SUBMISSION AS THE LOCAL PLANNING AUTHORITY

1.1. The following information is submitted in response to the information submitted at Deadline 7 by the Applicant (National Highways) for the A46 Newark Bypass for an Order granting Development Consent. Our comments follow the Council's previous comments, listed below:

1.2. The comments made for Deadline 8 are made by Newark and Sherwood District Council in their statutory role as the Local Planning Authority (LPA) and not as landowner. Newark and Sherwood District Council, in their landowner responsibility will not be making any comments for this deadline and it is understood that discussions on land acquisitions are still ongoing but that a resolution has been made.

# Additional Wireframe from Great North Road looking north towards Cattle Market Junction

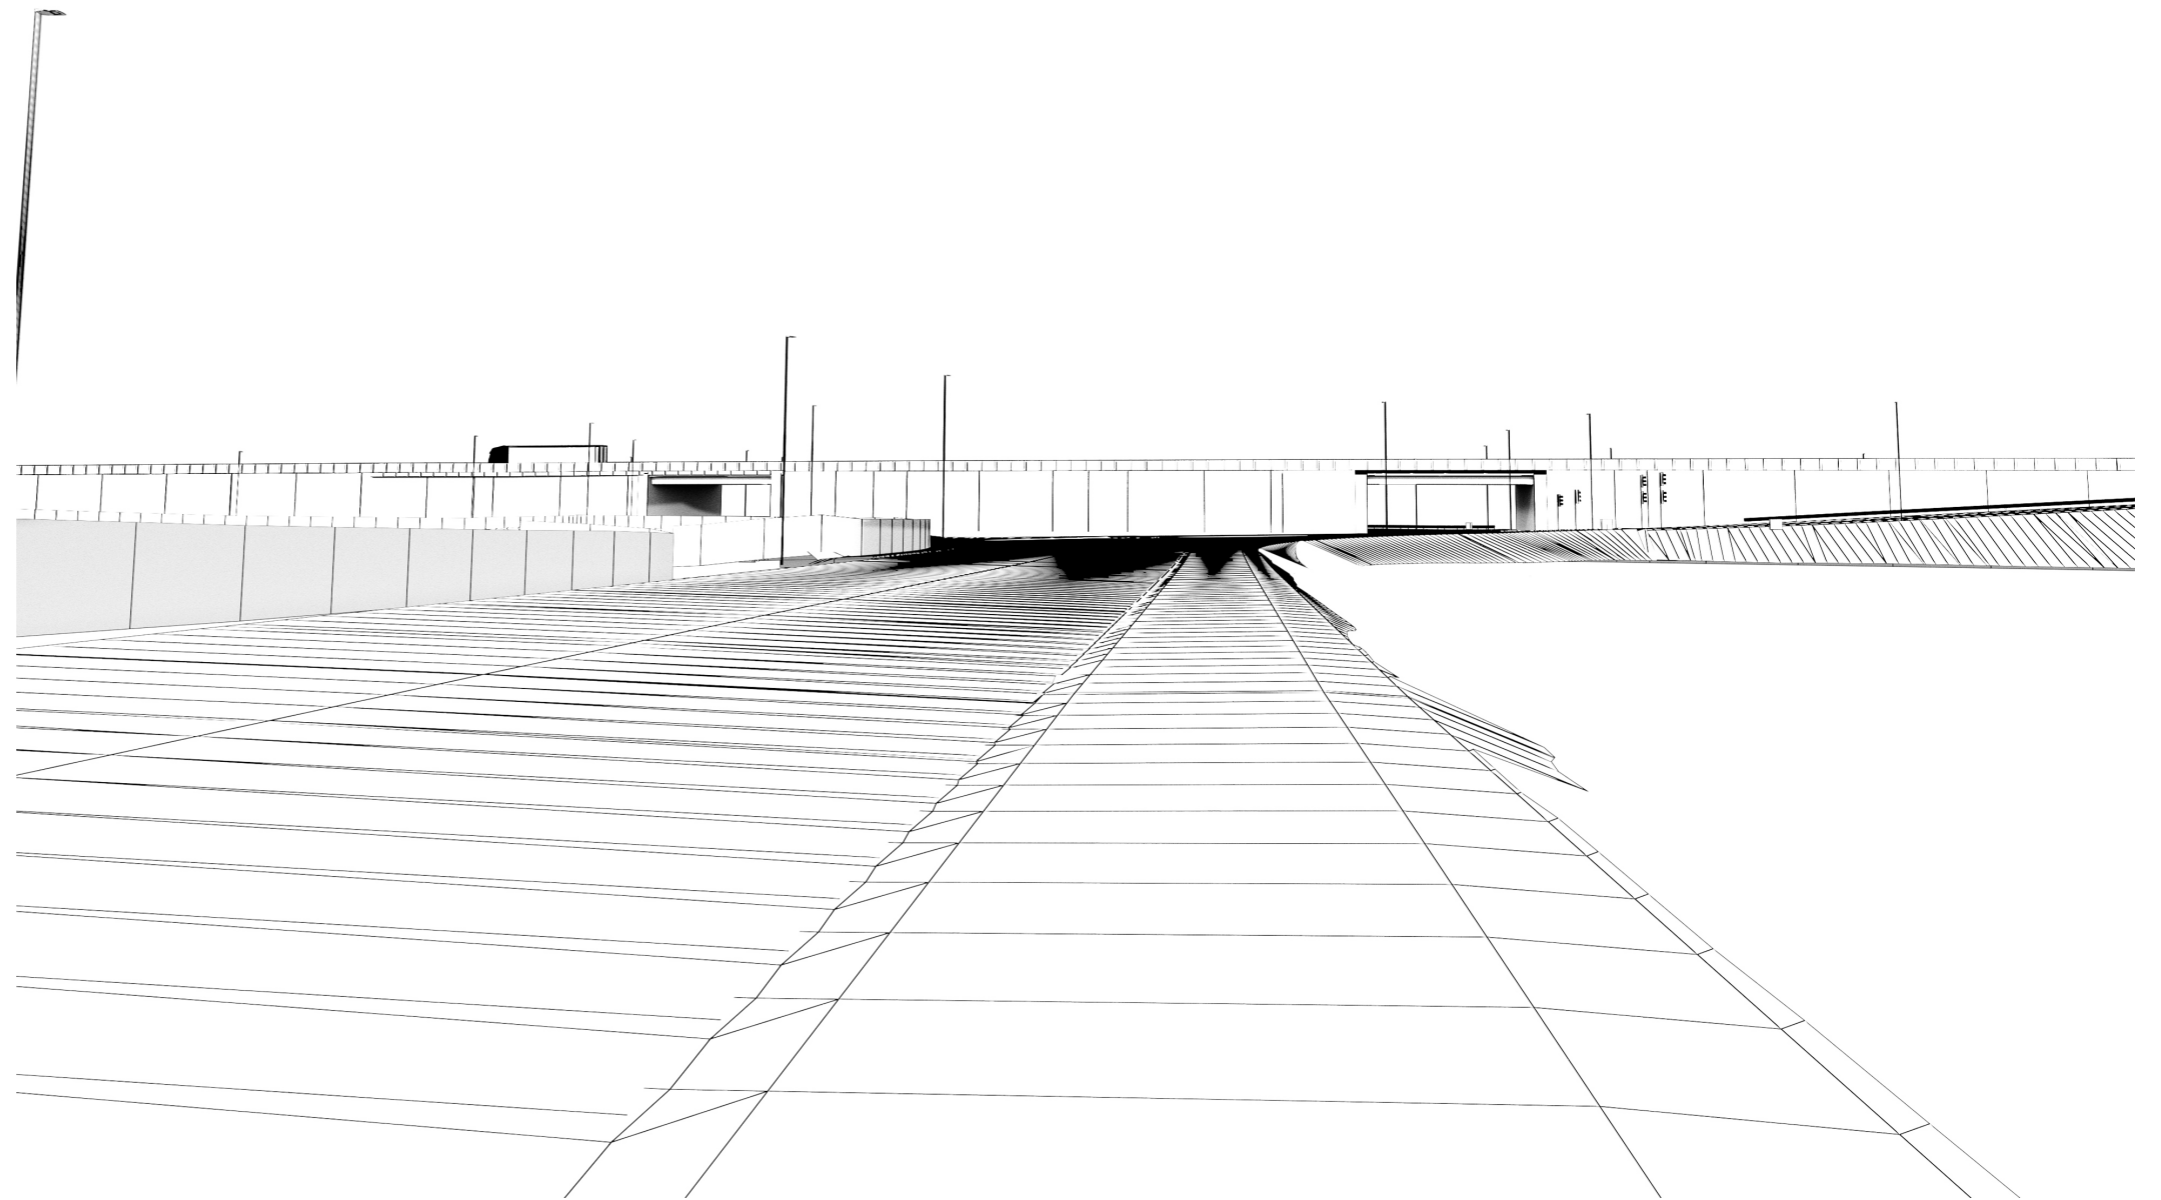
- 2.3. The finishing materials of the Cattle Market Grade Separated Junction (Q10.0.1 REP7-103).** This was raised by NSDC in REP5-067 (para 2.11) in response to the applicant's submission of REP4-040, where we raised a concern of the use of a single band at very low level on the structure. It was acknowledged by the applicant in later submissions that the use of the pale blockwork was as discussed prior to the submission, however this was when NSDC and other parties did not know the full extent of the flyover so was not in a position to understand its harm and the impact the colour of the finish would have. NSDC and NCC have had a meeting with the Applicant to discuss this (01.04.2025) and a solution to amend the wording in the Design Report was discussed in order to capture a change to the colour of the external materials. NSDC and NCC are both seeking a design which incorporates more red banding as opposed to the grey. Newark and the Nottinghamshire area is notorious for red brick, and this would be more akin to its character. The matter of creating a clash or competing with Smeaton's Arches is not considered to be an issue given the extent of the Arches which are visible above the highway level. The flyover would, if consented, still be the most dominant infrastructure in the landscape regardless of the colour of the material proposed.
